SSD 7081 - SYDNEY UNIVERSITY FACULTY OF ARTS AND SOCIAL SCIENCES - EIS

ATTACHMENT A

- ENVIRONMENT PROTECTION AUTHORITY COMMENTS -

SYDNEY UNIVERSITY FACULTY OF ARTS AND SOCIAL SCIENCES PROJECT

Figure 3 - Proposed Main Switchroom Location in FASS Building

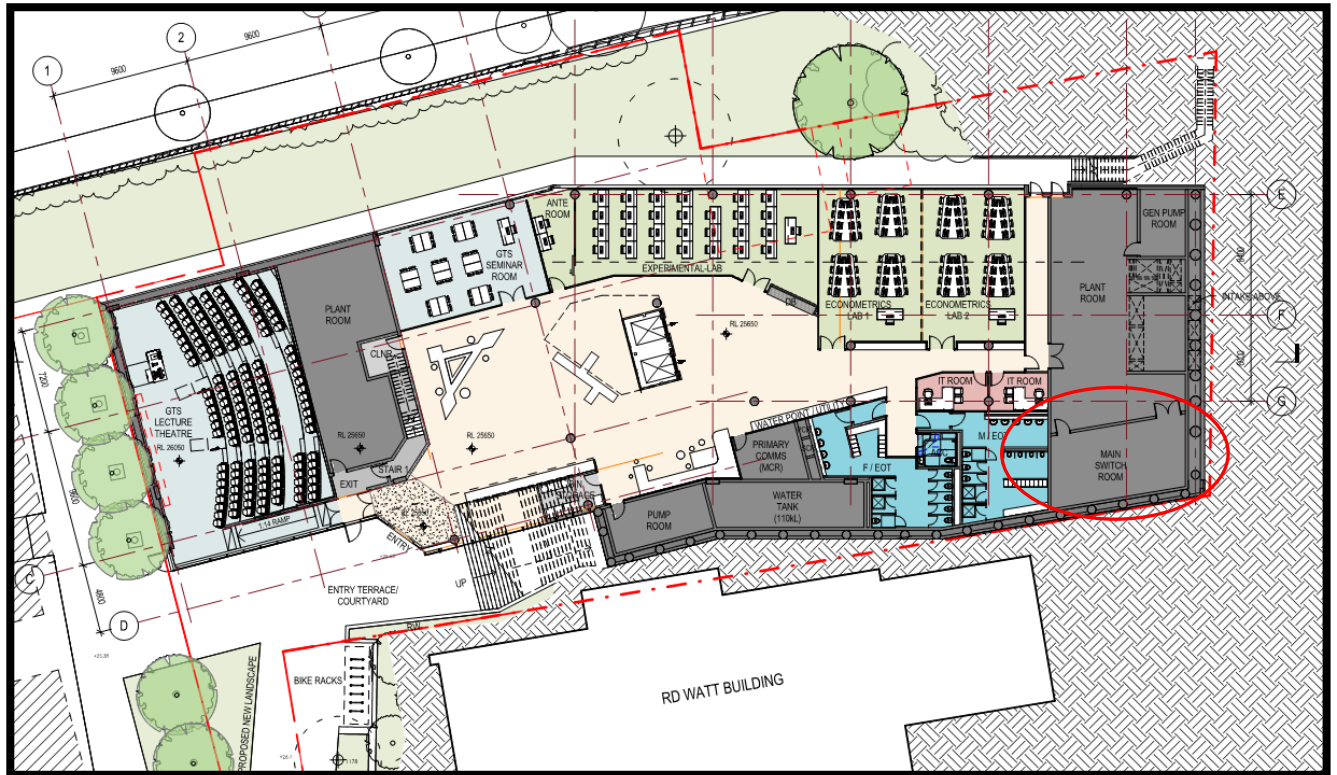
EIS section 1.6.2 (p.16-17) indicates at that substation No. 54 and switch room, and the Ross Street storage facility (dangerous goods store) are to be demolished pursuant to a separate assessment process. The EPA notes the potential for PCB and other chemical contamination associated with the substation and chemical store. However, the EPA is unclear whether those buildings were demolished prior to undertaking the detailed site contamination investigation'.

EIS Appendix CC 'Detailed Site Contamination Investigation' does not appear to explicitly address the issue of potential PCB contamination associated with substation No.54.

The EPA understands that soil sampling during the detailed site investigation was undertaken in the vicinity of the existing structures but would not have extended to those areas of the site beneath the footprint of those structures. Thus, the proponent should undertake further assessment following demolition of those structures and prior to any earthworks, including investigation of –

- potential PCB contamination within the footprint and immediate surrounds of the demolished substation No.54, and
- localised chemical contamination within the footprint of the ‘Ross Street’ dangerous goods store).

The proponent be required to undertake further assessment of soil contamination following demolition of existing structures and prior to undertaking any earthworks.
